Response to Submissions

ISSUES	RESPONSE
City of Sydney	
<i>Architecture, Bulk and Scale</i>	
The quality of the architecture used is questioned and the proposal results in a bulky mass including the new tower. The proposed tower is 76 metres long, whereas City residential towers are not to be more than 40 metres long.	Consideration has been given to reducing bulk and scale and increasing articulation on the western façade of the building. The principles that have been incorporated are described in Section 2.1 of the EAR and in the architectural plans at Volume 2 of the PPR. The bulk and scale of the western façade has been reduced by creating a more articulated building composition and recessing the two stairwells at the north and south ends of the building. Two vertical recesses have been re-distributed across the façade to further reduce the visual façade length to approximately 22 metres between recess slots.
A design competition is required for a development of this scale.	As this proposal was not subject to Part 4 of the EP&A Act, the requirements of Sydney LEP 2005 were not mandatory. Nevertheless, as described in section 6.3.2 of the EAR, the design process undertaken by th

Level 2 - Podium Plan

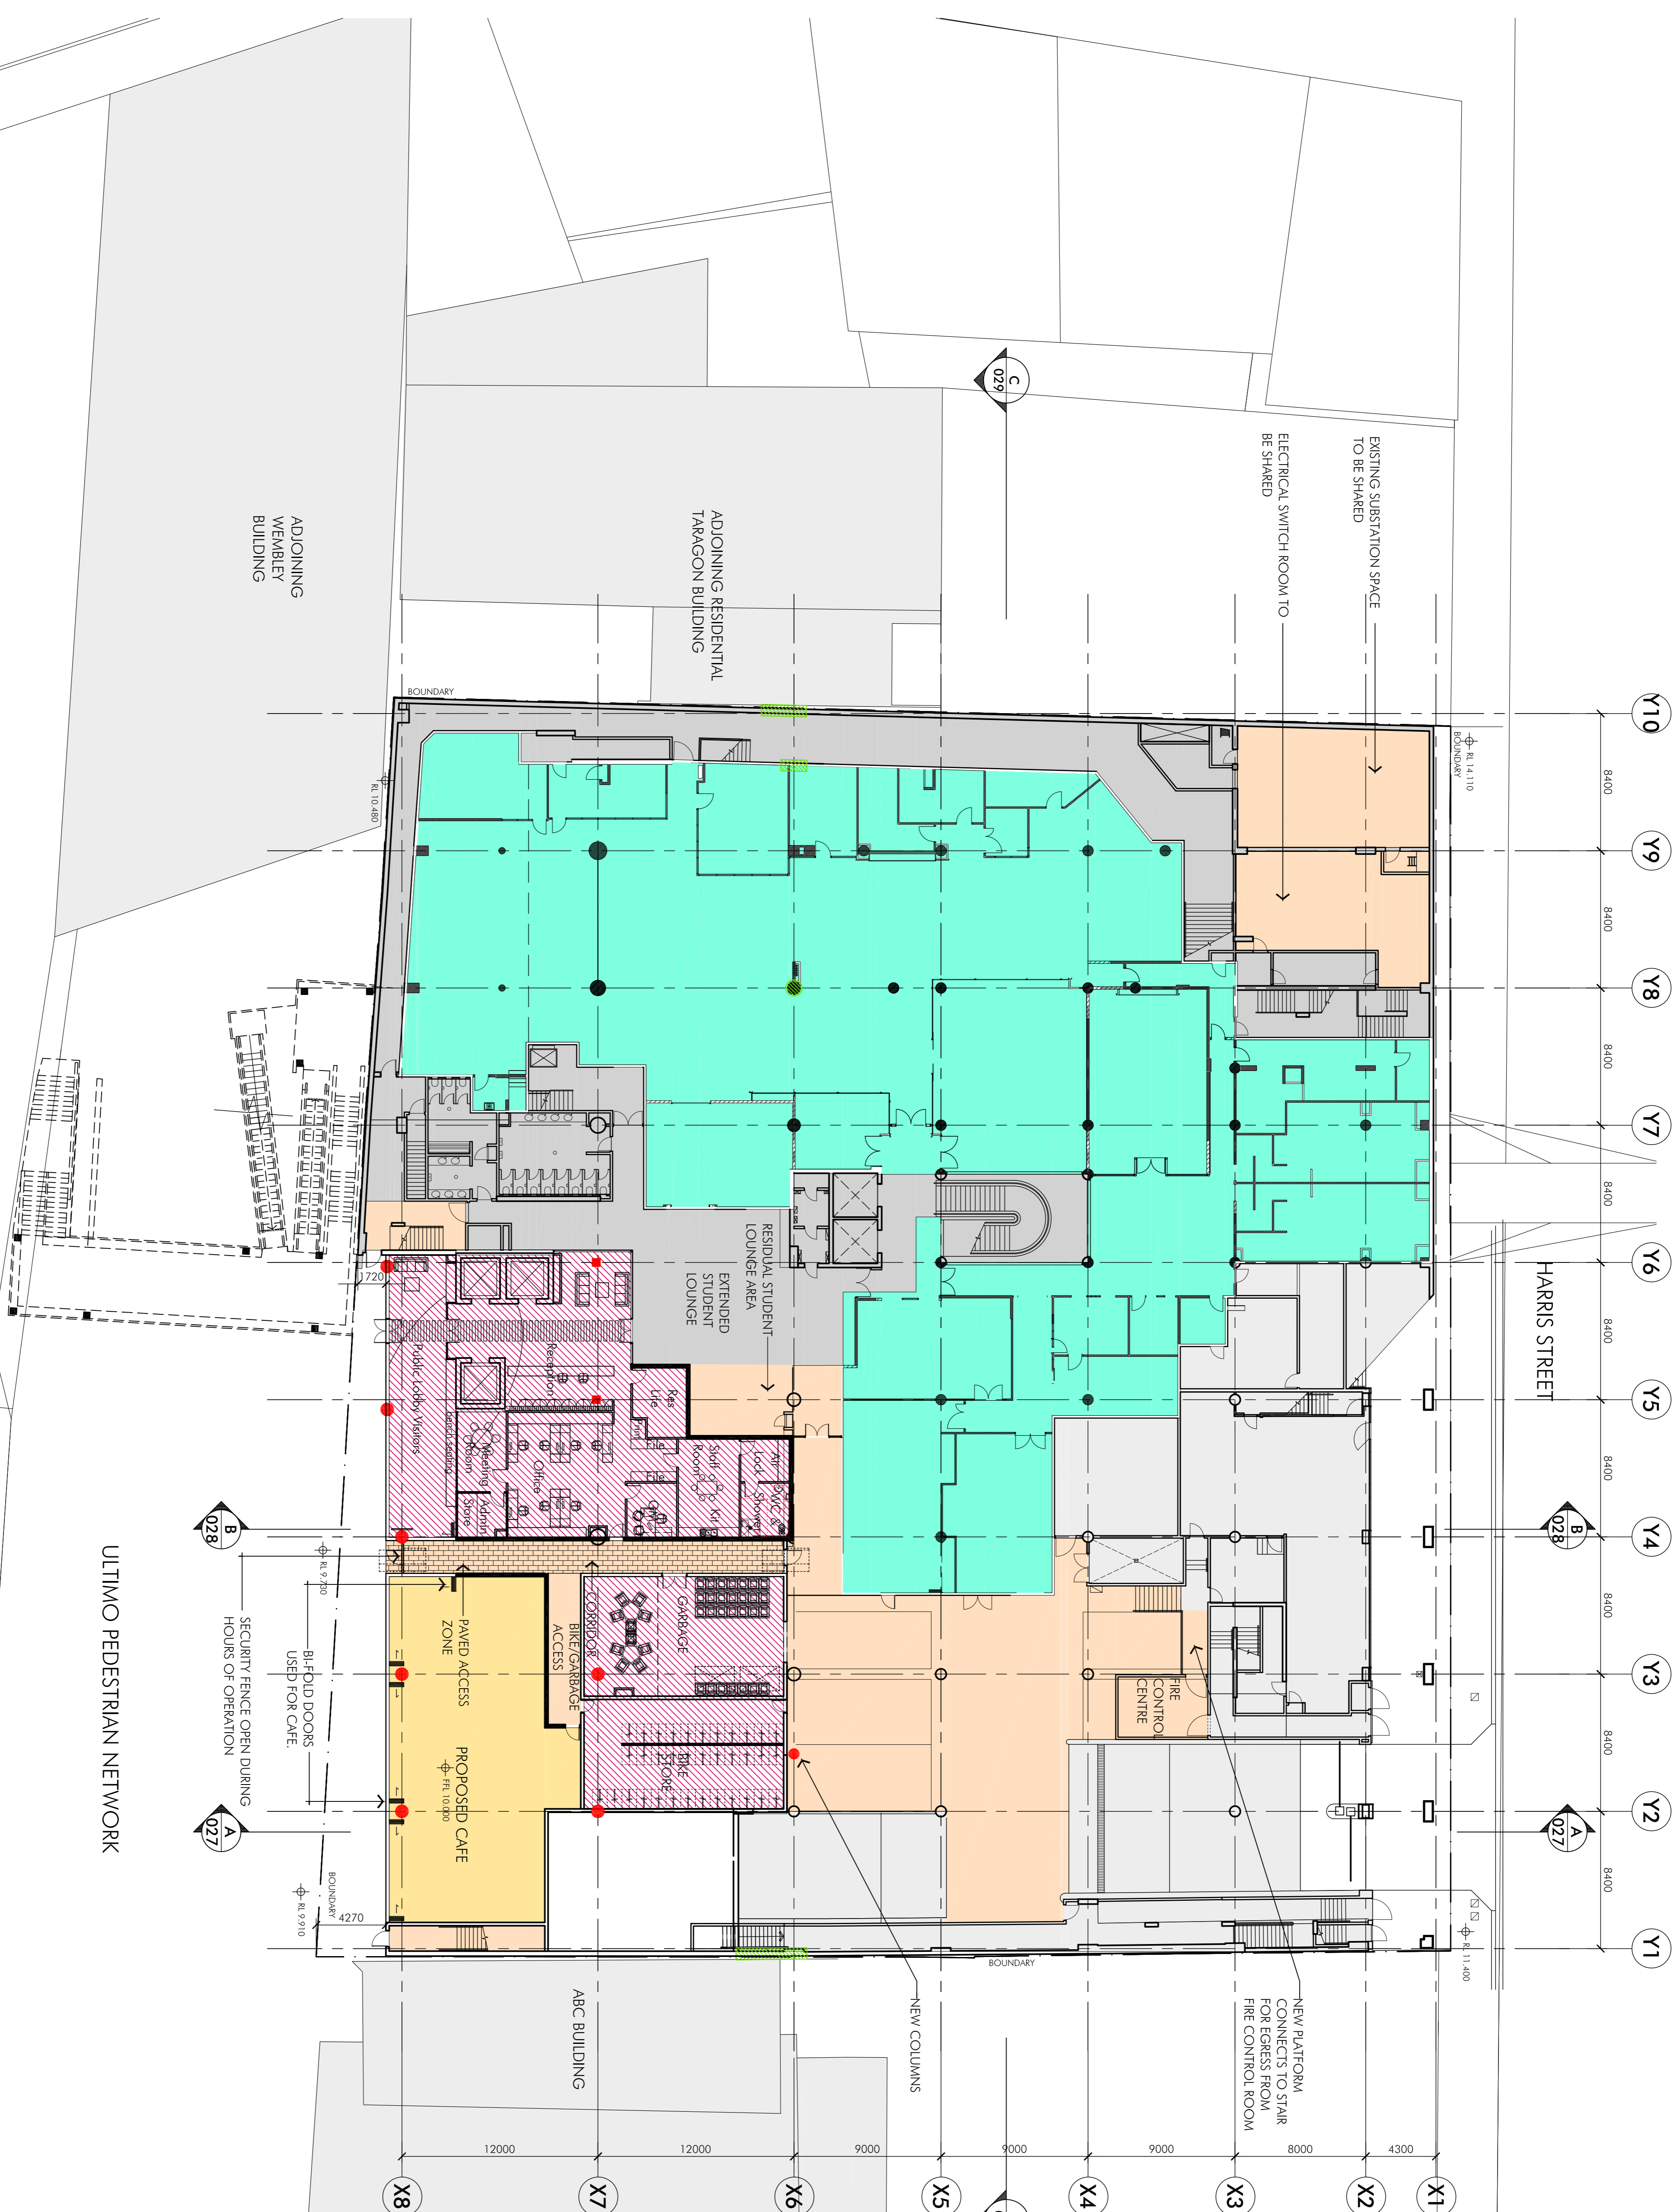
The height of the podium should match the height of the indented podium of the adjoining ABC building.	The datum line generated by the indented podium of the ABC building appears somewhat arbitrary as it is localised to only that small portion of the ABC building and is not reflected on the façade of any of the other adjacent buildings along the UPN streetscape. The fact that the ABC podium element is indented and separated from the UTS site by a strong vertical shadow line form raises the question of the strength of this element as a dominant datum line. It is also noted that the proposed podium and tower on PJB does not materially differ from the bulk of the existing DA which was designed by Cox. Cox also designed the ABC Building. In the design of the ABC Building, Cox chose to not make the height of the ABC indented podium match part of the approved UTS scheme.
The treatment of the façade should be opened up more to allow passive surveillance and viewing into the UPN and vice versa.	The UPN façade has been designed to achieve a balance between promoting passive surveillance and viewing into the UPN on the one hand, and accommodating UTS's teaching space requirements. Incorporating a screen mesh has lightened the façade while the operable window areas facing the UPN on the first two floors facing the UPN have increased visual surveillance of the UPN. Solid walls are needed at higher levels of the podium to accommodate UTS's interior layout and the functionality of the studio space. Windows will be used to allow light to penetrate into the building and provide interest to the UPN façade.

Remove the overhead bridge and escalators.	General pedestrian access from the UPN was not part of this proposal. The UTS Concept Plan addresses in detail the connectivity of the campus as a whole. Opportunities to further improve access from the UPN to the PJB and main part of the UTS campus, will be explored by UTS in the future.

HARRIS STREET: WEST PART ELEVATION

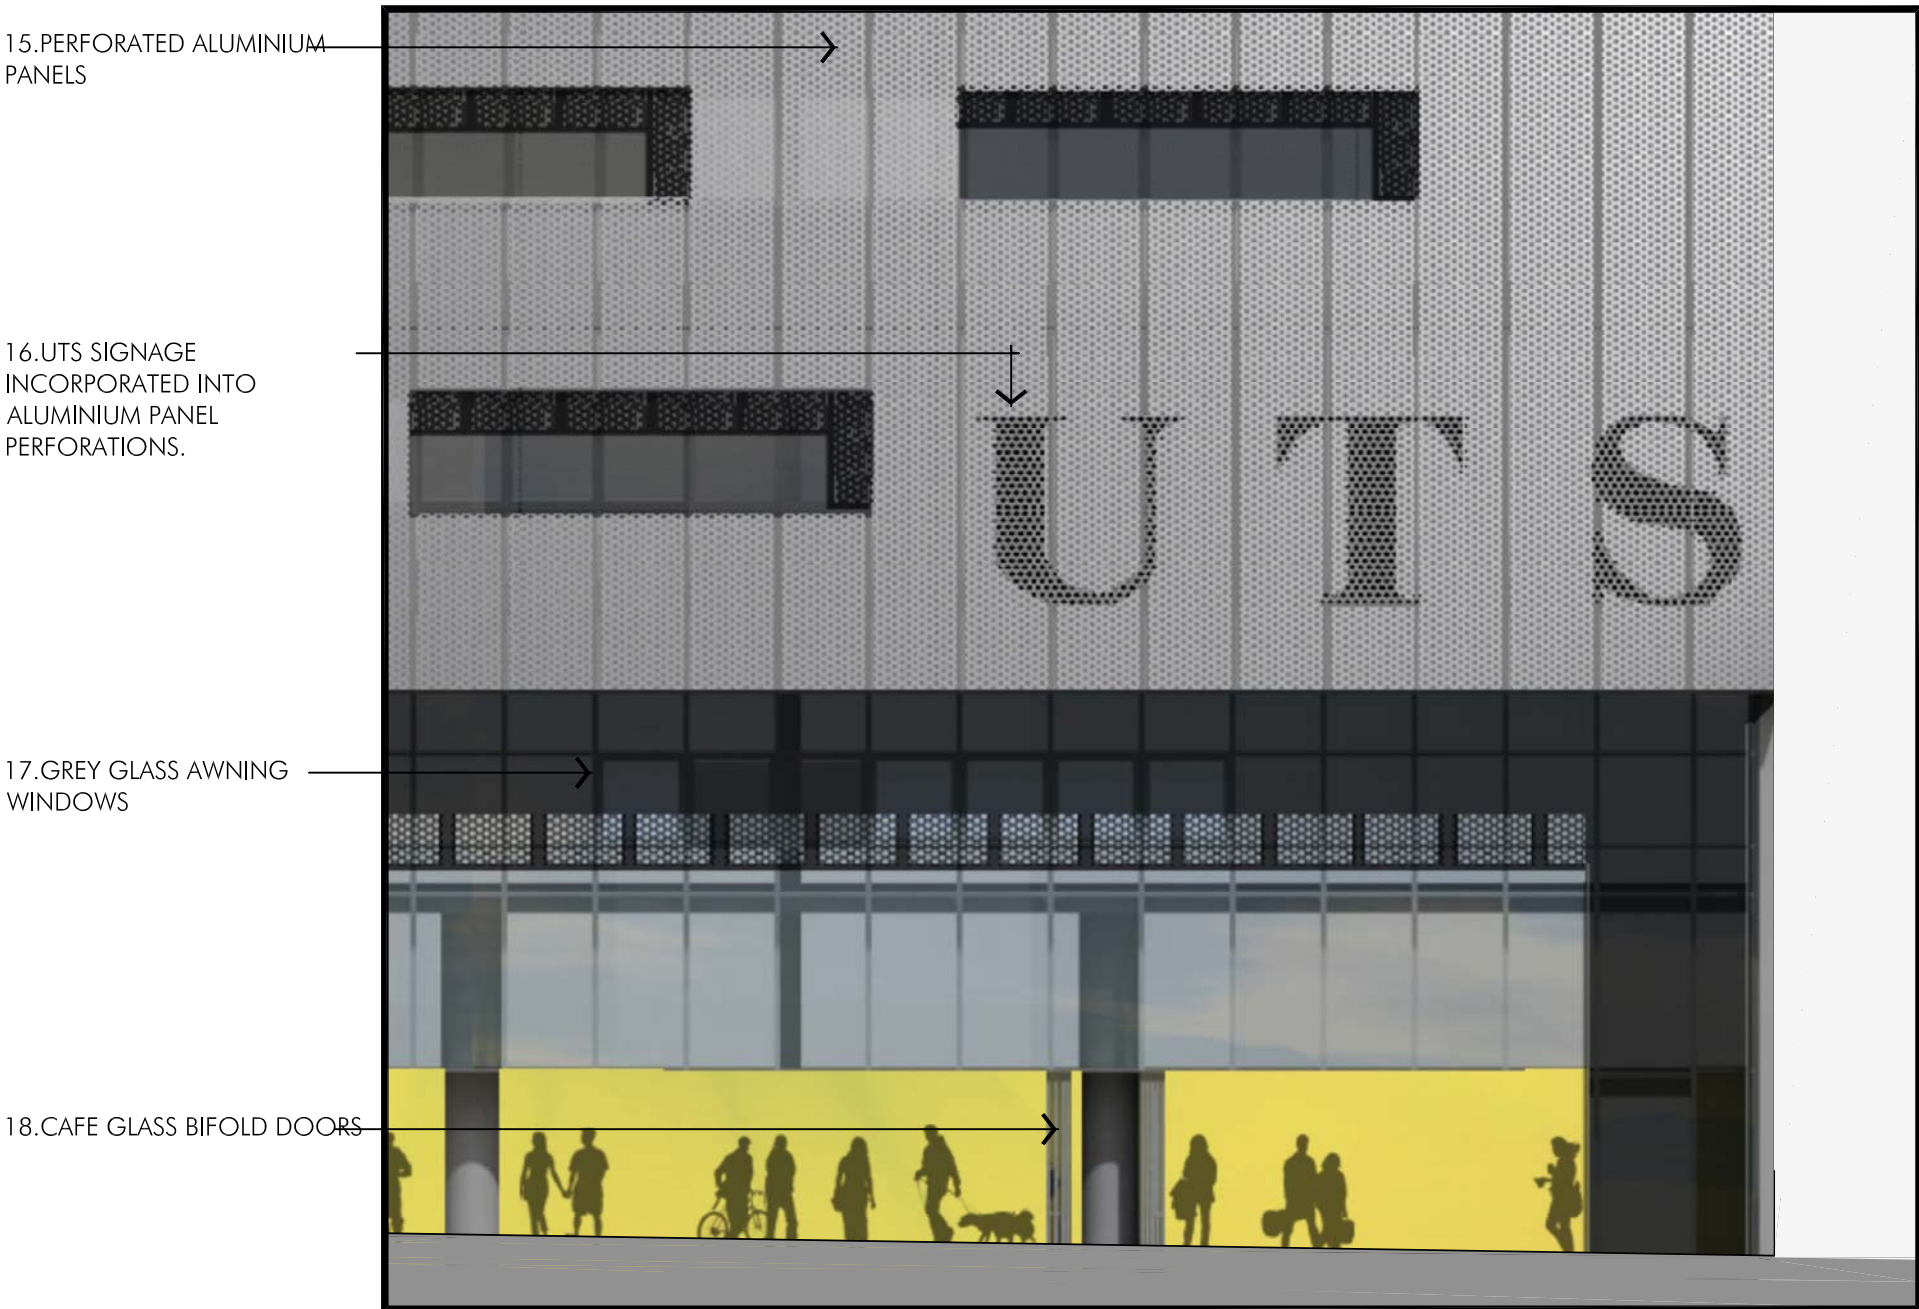
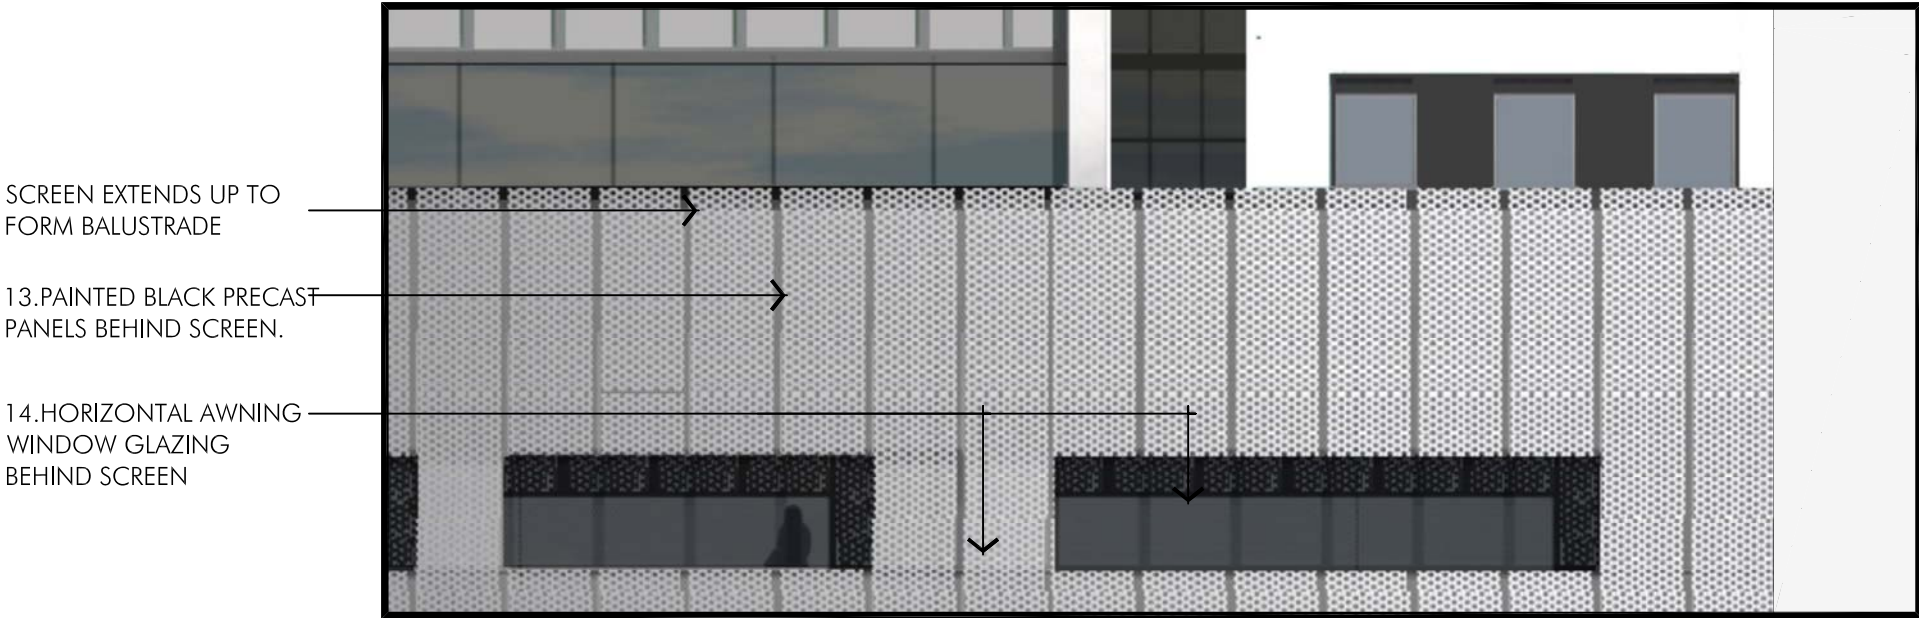
The patterned façade is insensitive to the heritage building on the corner of Broadway and Harris Street.	In response to the change in the western façade composition, the pattern of pre-cast panels has been re-interpreted using three different size panels that are repeated every three floors to break up the visual bulk and scale. The pattern incorporates recessed vertical windows of three different sizes to create a dynamic and varied window treatment. Neutral tones are used to complement adjoining buildings.

ISSUES	RESPONSE
The patterned façade is insensitive to the heritage building on the corner of Broadway and Harris Street.	The revised design of the western façade has resulted in a more textured and articulated building composition, which contributes positively to reducing the visual scale and mass and complements the context of neighbouring buildings and heritage buildings without strictly imitating those buildings.
There is an active consent for a commercial tower on the site.	Noted
If the overall height is retained, the detailing of the architecture and facades should be improved and building mass broken up and lightened with more suitable materials.	The façade has been articulated through the introduction of two vertical slots, colour and additional windows. This reduces the overall mass of the solid areas of the façade and lightens the colour of the façade.
<i>Podium to Ultimo Pedestrian Network (UPN) and Public Domain</i>
